## **A57 LINK ROADS**

**TR010034**

**RESPONSES TO DEADLINE 4 SUBMISSION**

**CPRE PDSY REBUTTAL OF NH'S RESPONSE TO OUR WRITTEN REPRESENTATION - REP2-069, REP2-070 AND REP2-071**

100
0
10
Millimetres
DO NOT SCALE

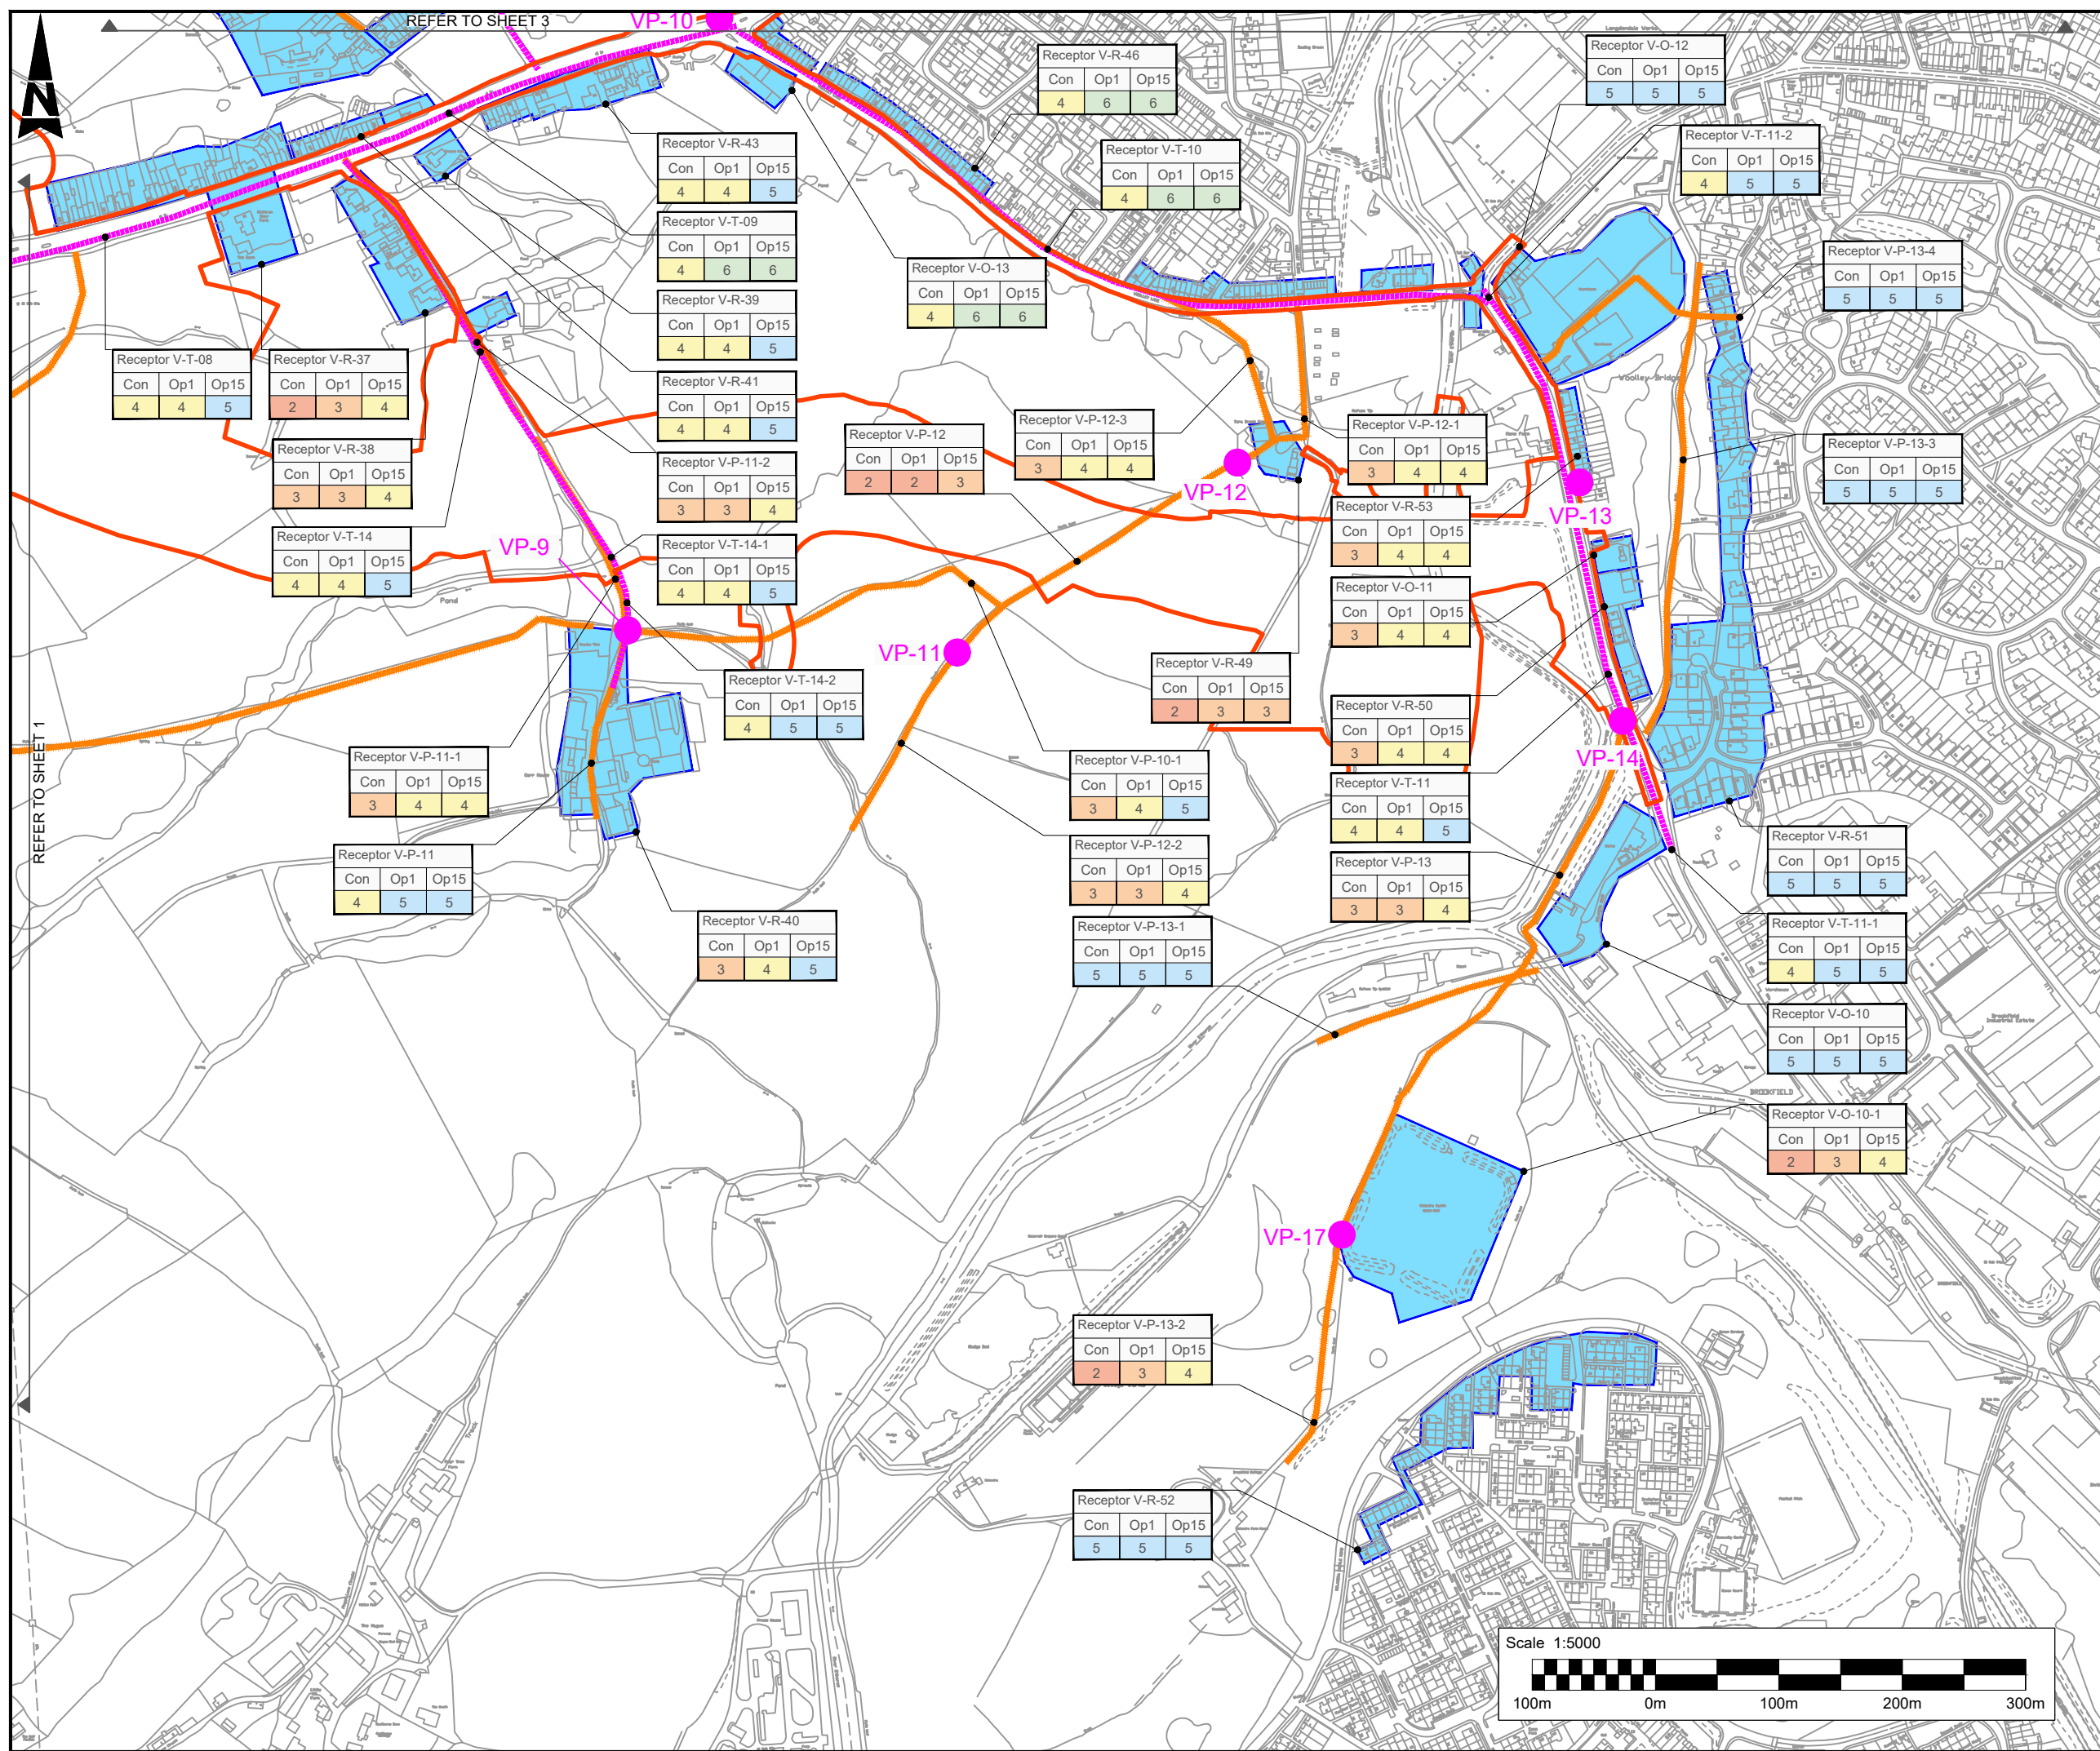
<p>Visual Effect</p> <p>6.2.17 The Applicant notes that a separate methodology is relied upon for the CPRE visual assessment, as per 4.7.48 through to 4.7.50 (REP2-</p>	<p>As above CPRE followed the guidance set out in GLVIA3. In our view NH's assessment did not fully capture or describe, and underplayed, the visual effects of the scheme.</p>

<p>069) (page 82), of the Written Representation and this is not clear (in terms of relevance and basis), and therefore cannot be commented on.</p> <p>6.2.18. As per ES Chapter 7: Landscape and Visual Effects paragraph 7.3.3 'A detailed landscape and visual assessment has been undertaken following the requirements of DMRB LA 107 standard. The assessment is also informed by guidance set out in GLVIA3 and GLVIA3 Statements of Clarification.'</p> <p>6.2.19. Additionally and as per ES Chapter 7: Landscape and Visual Effects Paragraph, Paragraph. 7.3.5: 'The assessment was undertaken by two chartered Landscape Architects (LA's) experienced in LVIA and their professional judgement was used in line with GLVIA3.'</p>	
<b>EFFECTS ON PEAK DISTRICT NATIONAL PARK</b>	
<b>National Highways Comments</b>	<b>CPRE PDSY Rebuttal</b>
<p>Increased Noise and reduced tranquillity</p> <p>4.8.19: Paragraphs 11.3.34 and 11.3.35 of the Noise chapter of the ES (REP1-017, REP3-007) provide details on how roads from the traffic model are selected for inclusion in the operation phase road traffic noise assessment. A map showing the locations of the roads within the study area of the Scheme is provided in Figure 11.5 (APP-134), which includes the A57 and A628. Traffic data from other roads located within the Peak District National Park were analysed for inclusion in the assessment, however, they did not meet the DMRB LA 111 requirements for inclusion in the study area as there were not predicted to change by 1 dB or more. Changes of less than 1dB are classified as negligible in the DMRB and would not be perceptible.</p> <p>7.2.2. 4.8.20: Paragraph 11.9.97 of the Noise chapter of the ES (REP1-017, REP3-007) states that minor increases were predicted on the A57 (Sheffield Road, Woodcock Road, Snake Pass and Snake Road) in the short-term and would be perceptible, and that negligible impacts would occur in the long-term. The impact magnitudes stated are based on the DMRB LA 111 assessment criteria reproduced in Table 11.9 of the ES.</p>	<p>We have responded to NH's approach towards tranquillity and dark skies in our submission for Deadline 4 REP4-016.</p>
